RFI Item 5 & 6: Biodiversity & AA

Faith Wilson Ecological Consultant (FEWC) prepared the Biodiversity Chapter within the EIAR and the Natura Impact Statement to support a planning application for a proposed Large-Scale residential development (LRD) and Creche on lands at Barrysparks and Crowscastle, Swords, Co. Dublin (ref. LRD0055/S3E) on behalf of Bovale Developments Unlimited Company.

Fingal County Council (FCC) issued a Request for Further Information (FI) seeking clarification on various items, including those associated with Item 5 (and more specifically, with the biodiversity aspects) and Item 6. A response to same has been prepared by FEWC.

Figure 2. The indicative locations of invasive species recorded on the Barrysparks masterplan lands.

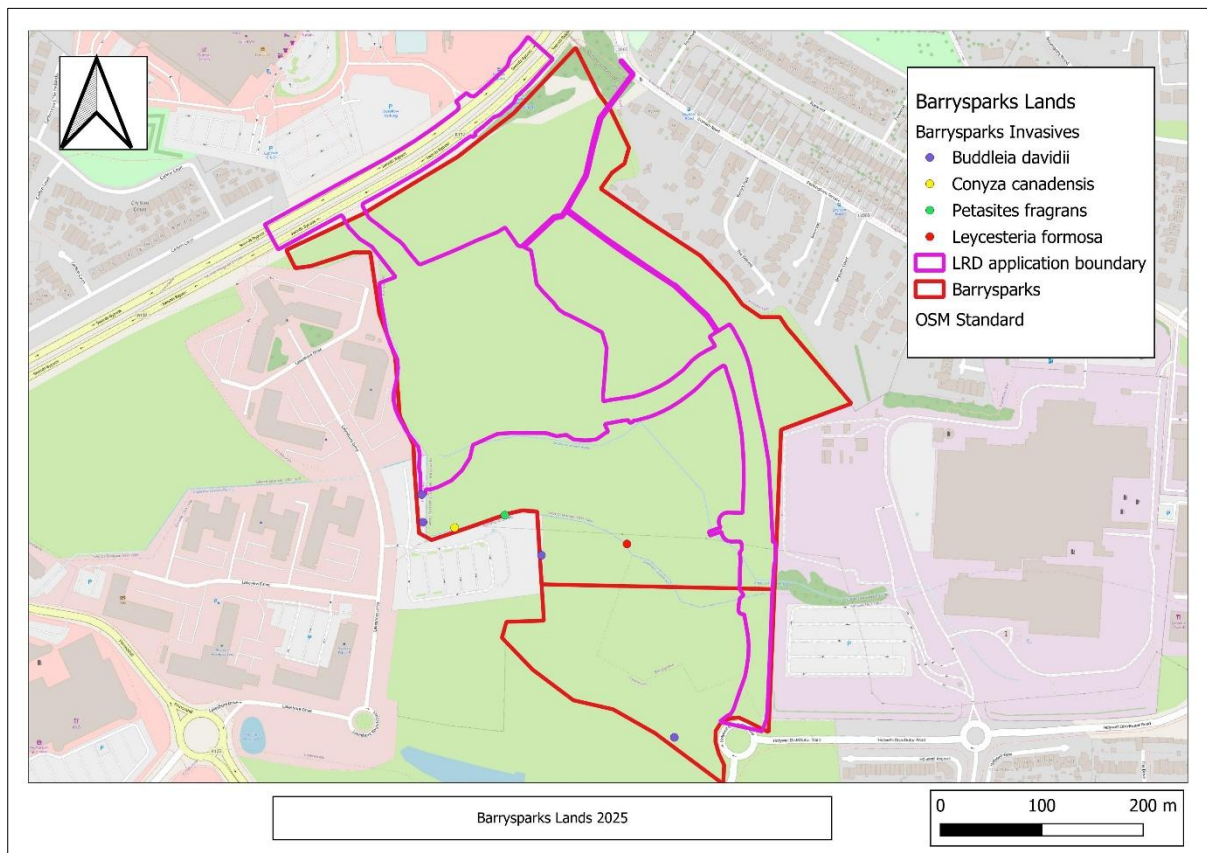
- xiii. It is not clear how invasive species *Buddleia (Buddleia davidii)*, Himalayan honeysuckle/pheasant berry (*Leycesteria formosa*), Canadian fleabane (*Conyza canadensis*) and Winter heliotrope (*Petasites fragrans*) are to be treated (chemical/physical) and if treatment will be required prior to the construction phase in order to prevent the further spread of these species during ground works. The Applicant is requested to provide an Invasive Species Management Plan for the treatment of *Buddleia*, Himalayan honeysuckle/pheasant berry, Canadian fleabane and Winter heliotrope. This Plan should be guided by best practice and include a treatment and monitoring regime appropriate to each species. The Plan must indicate when treatment of each plant will begin as well as any other avoidance/biosecurity measures required to prevent the spread of these invasive species.**

An Invasive Species Management Plan has been prepared and is enclosed. The measures set out within this plan have been included in the revised OCEMP.

Pond Location - Plan Layout
Scale 1:1000

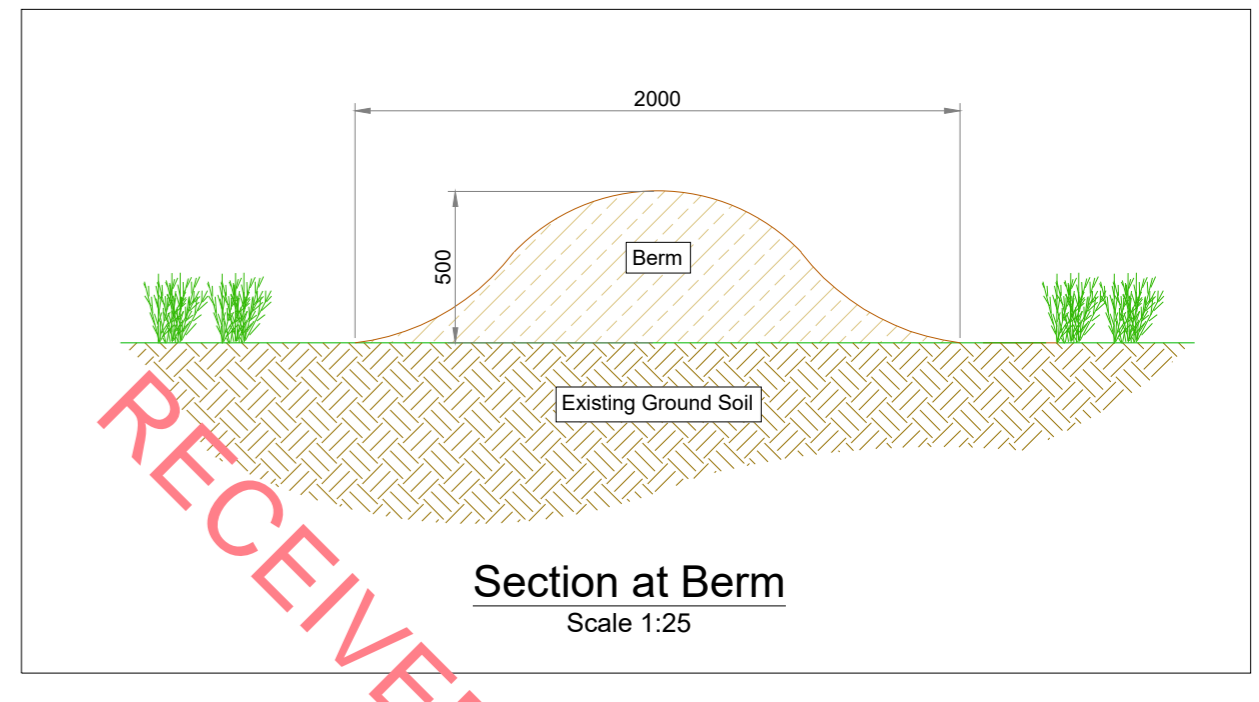
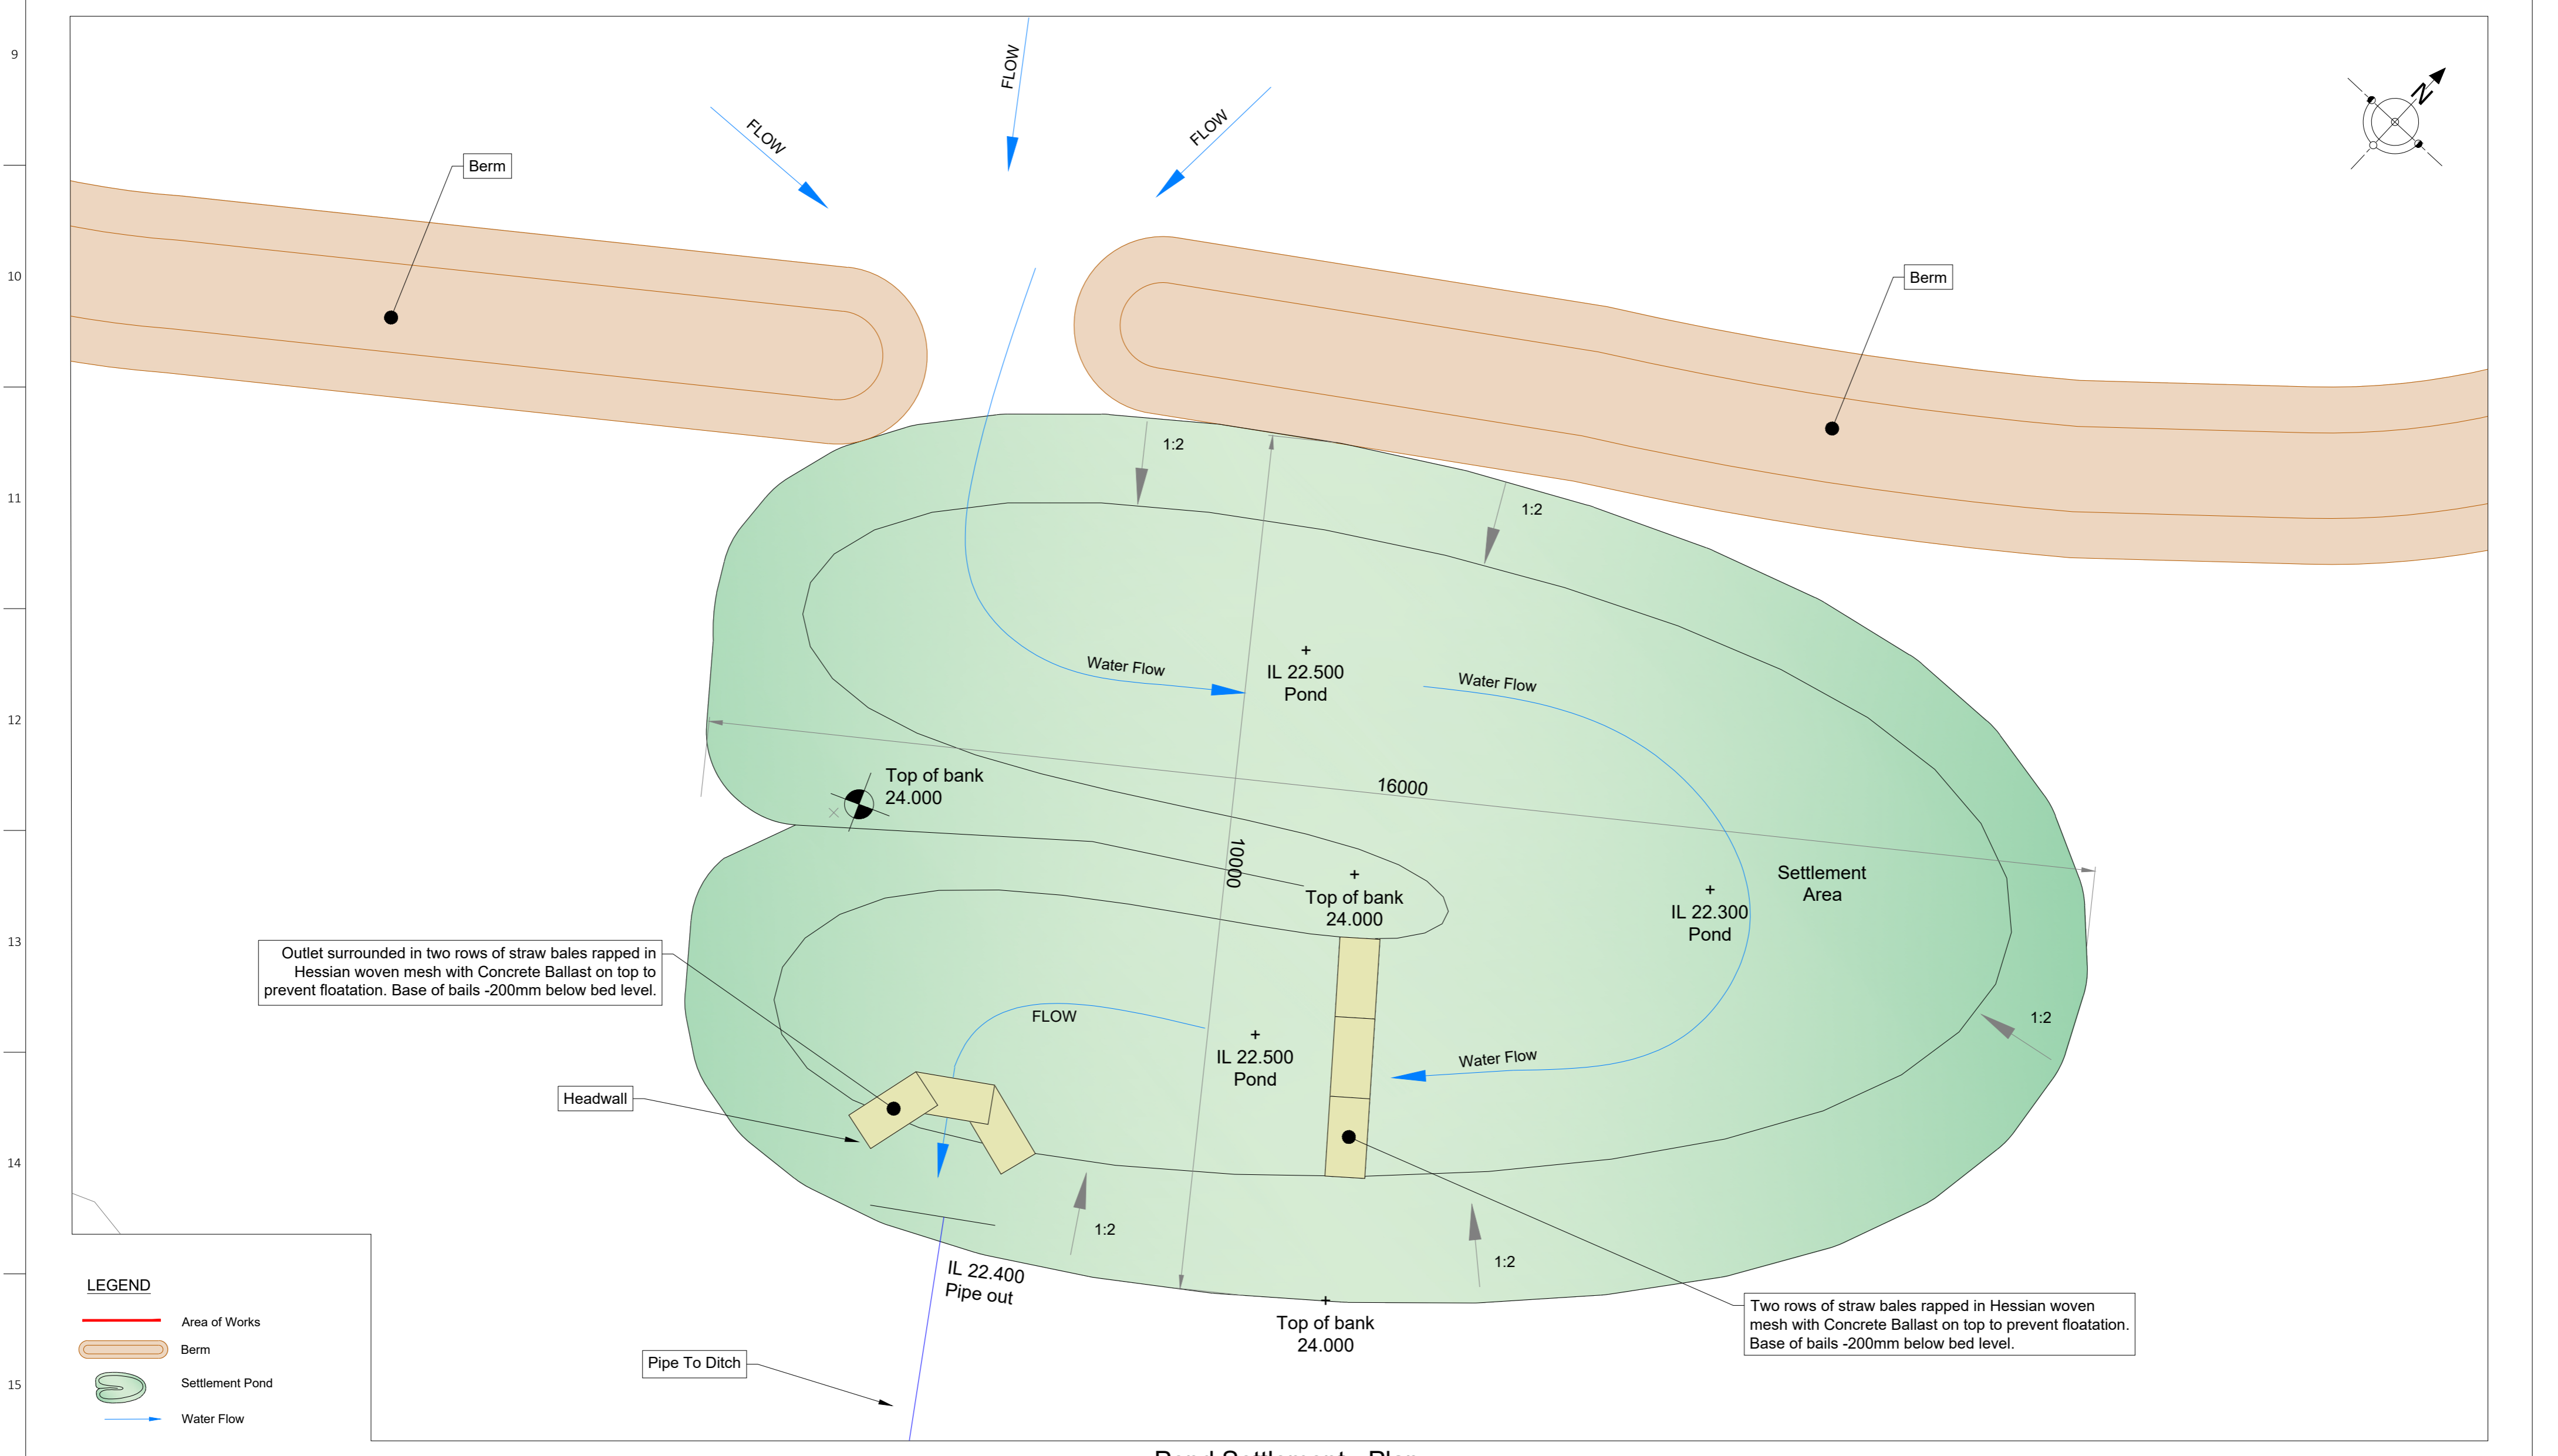
- ix. **The Applicant is requested to clarify Section 6.7.1.5 which states that 'During construction water will discharge to the existing drainage ditch that flows in the centre of the site as well as the Gaybrook Stream located along the site's western boundary, continues towards the southern boundary. Where required, a wastewater discharge licence will be applied for to manage surface water on site during the construction phase. This shall permit the discharge of trade effluent arising from groundwater/surface water ingress on the construction site'. The Biodiversity Chapter and OCEMP do not align with Section 6.7.1.5 in terms of the discharge of 'trade effluent'. The Applicant is asked to define appropriate mitigation measures to prevent significant effects on any key ecological receptors.**

- xii. Both the OCEMP and Biodiversity Chapter provide mitigation to protect surface water, however, no buffer/exclusion zone is provided that limits potential damaging activities to the drainage ditch and Gaybrook Stream during the construction phase. That is, there is no setback provided for the storage of materials and chemicals, or refuelling and maintenance works to machinery. The Applicant is requested to define additional mitigation to ensure adequate protection of Gaybrook Stream and its associated drainage ditch.**

This error has been corrected in RFI Item 5: Land & Soils and Water & Hydrology. In summary surface water runoff from the construction areas will be directed to a settlement pond/ tank prior to outfall to the drainage ditch. This aligns with the proposal in both the Biodiversity Chapter and the OCEMP.

Mitigation measures that ensure the protection of the Gaybrook Stream, including a setback for the storage of materials and chemicals, have been provided in the revised OCEMP.
